Our ref: RA/2024/147529/01-L01
Your ref: 2024/92236

Date: 18 October 2024

DEMOLITION OF EXISTING INDUSTRIAL BUILDING AND ERECTION OF STORAGE AND DISTRIBUTION BUILDING WITH CAR PARK AND ASSOCIATED ENGINEERING WORKS – WOOD STREET MILLS, WAKEFIELD ROAD, SCISSETT, HUDDERSFIELD, HD8 9JS

Objection – Development over/too close to existing culvert – unlikely to be able to grant Flood Risk Activity Permit (FRAP)

Title:  
Proposed Site Plan (Floor Plan)

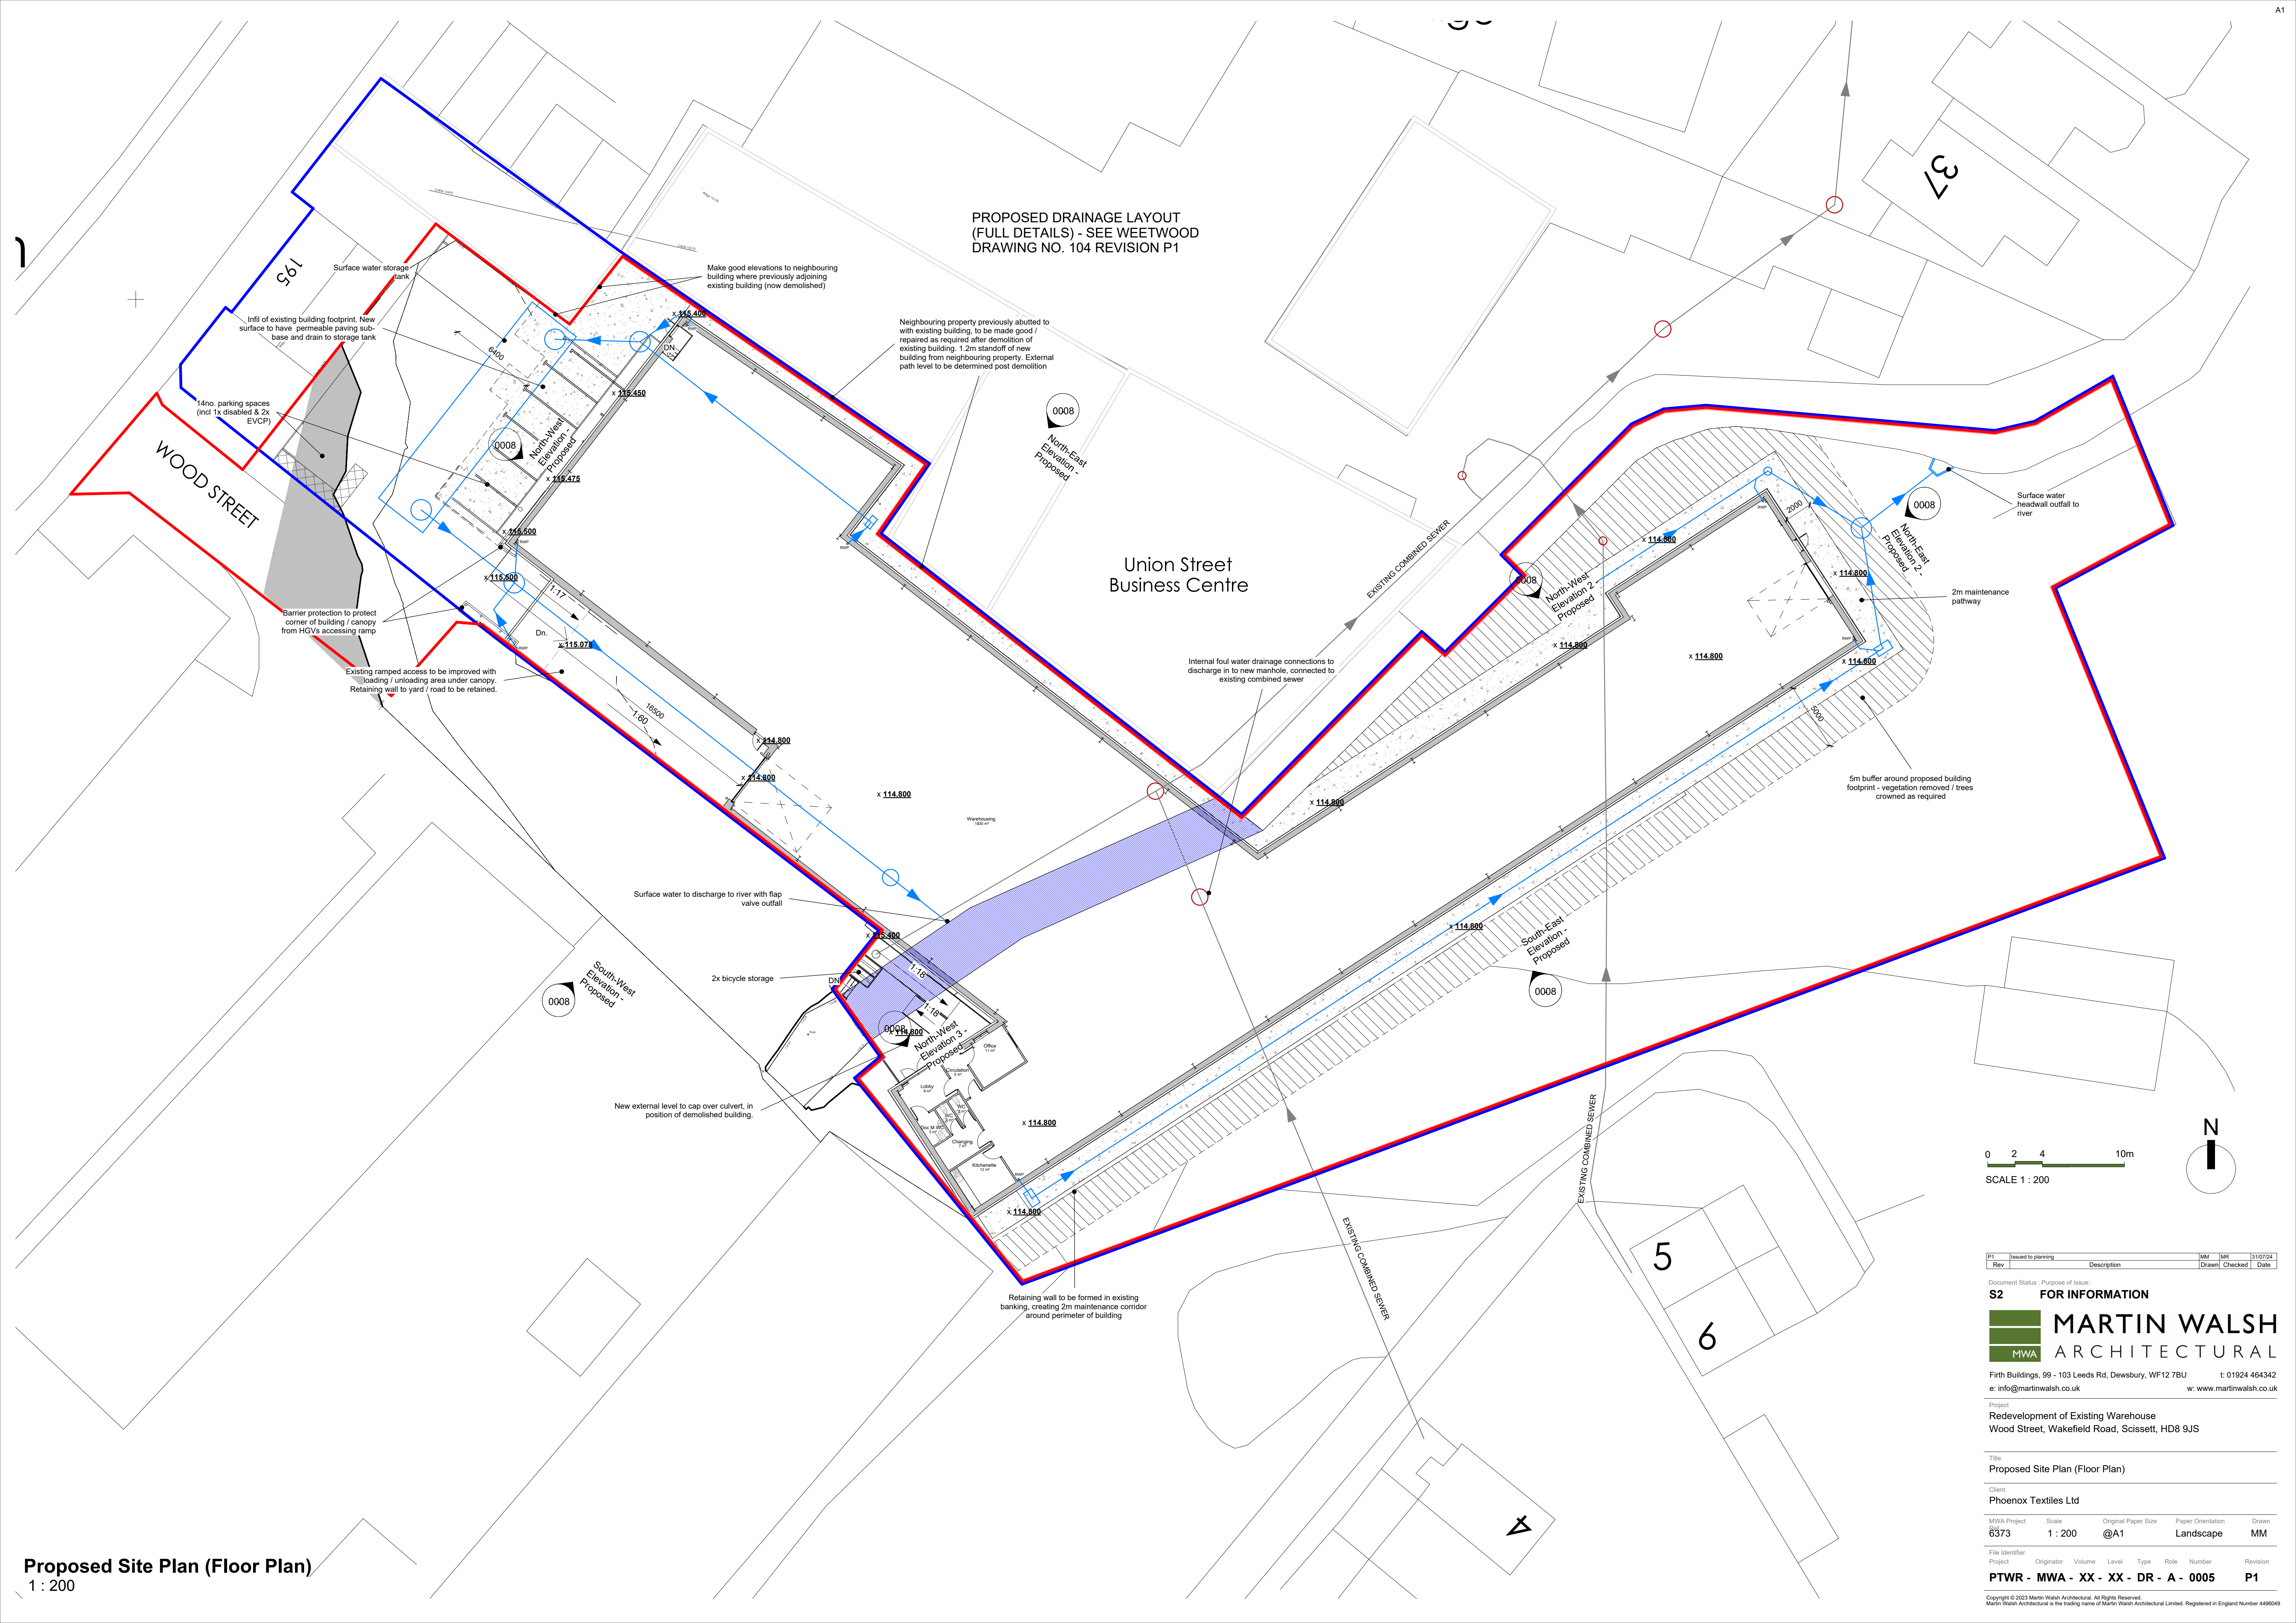
The proposed demolition and construction is taking place on top of an existing main river culvert carrying the River Dearne, therefore the proposed development will require a Flood Risk Activity Permit, as explained below, in addition to planning permission.

The proposed development may prevent the reversal of a substantial loss of watercourse habitat due to building over, and within 8 metres of, the existing culvert. There is a significant risk that the development may prevent achievement of good ecological potential and therefore cannot proceed except under the provisions of Article 4.7 of the Water Framework Directive.

The river is entirely culverted within the red line boundary (about 30 metres in length) but, immediately downstream, the Dearne is open channel. Upstream of the development, the river is intermittently in culvert over approximately a 200 metre length through the mills, but then runs in an open channel above that. As the site is being redeveloped, this provides a rare opportunity to incorporate WFD mitigation measures into the development by de-culverting this section of the River Dearne, in accordance with the Humber RBMP and local planning policy. The *Dearne from Source to Bentley Brook GB104027063220* water body is currently failing to achieve its objective of Good Ecological Potential (the current status is Moderate). The water body is failing for its mitigation measures assessment, as identified measures and associated actions have not been put in place, including the mitigation measure 're-opening culverts'.

It may be possible to overcome our objection by demonstrating, to the satisfaction of the LPA, that the applicant has considered and assessed all practical options for complete or partial de-culverting of the River Dearne in the design of their development, and for maintaining an 8 metre buffer zone from the watercourse wholly, or substantially, free of built development.

Modified proposals incorporating such de-culverting and buffer zone should be submitted.
